CITY OF PORTLAND

June 20, 2000

RE: Lot 168 (144) Milton Street
CBL: 333-E-033
Permit # 000528

PLOT PLAN

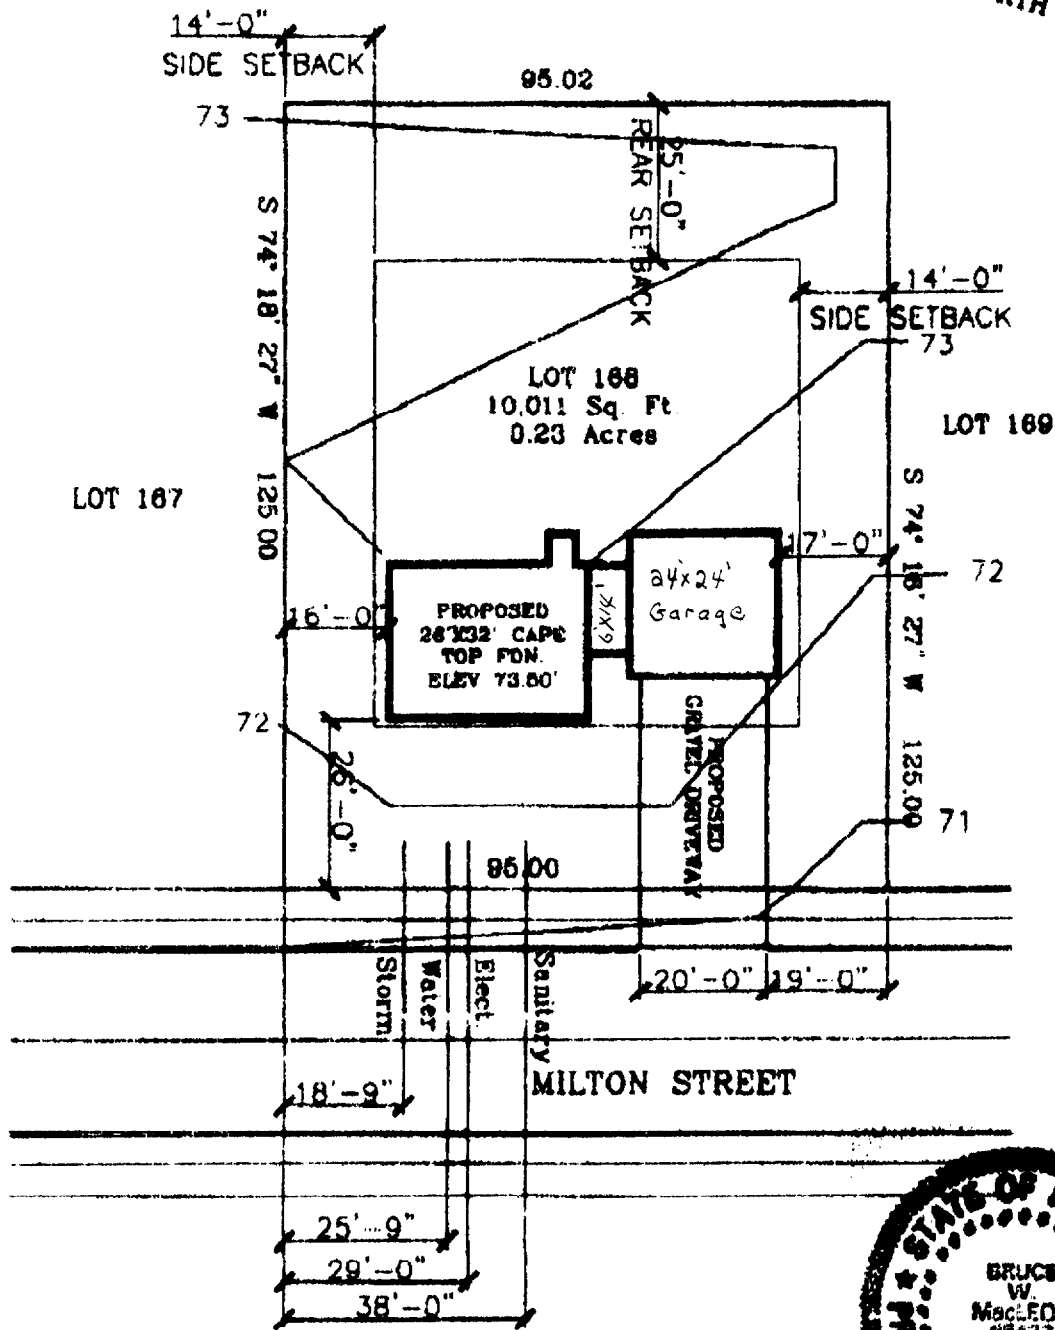
Foundation wall placed in wrong place. It is too close to front lot line. Also, foundation wall was placed without required inspection by this office.

An engineer's report must be presented to this office describing methods to be used to tie in new concrete wall to the existing foundation. Also an amendment must be applied for to reflect any changes in size or design of the structure. You must comply by July 5, 2000.
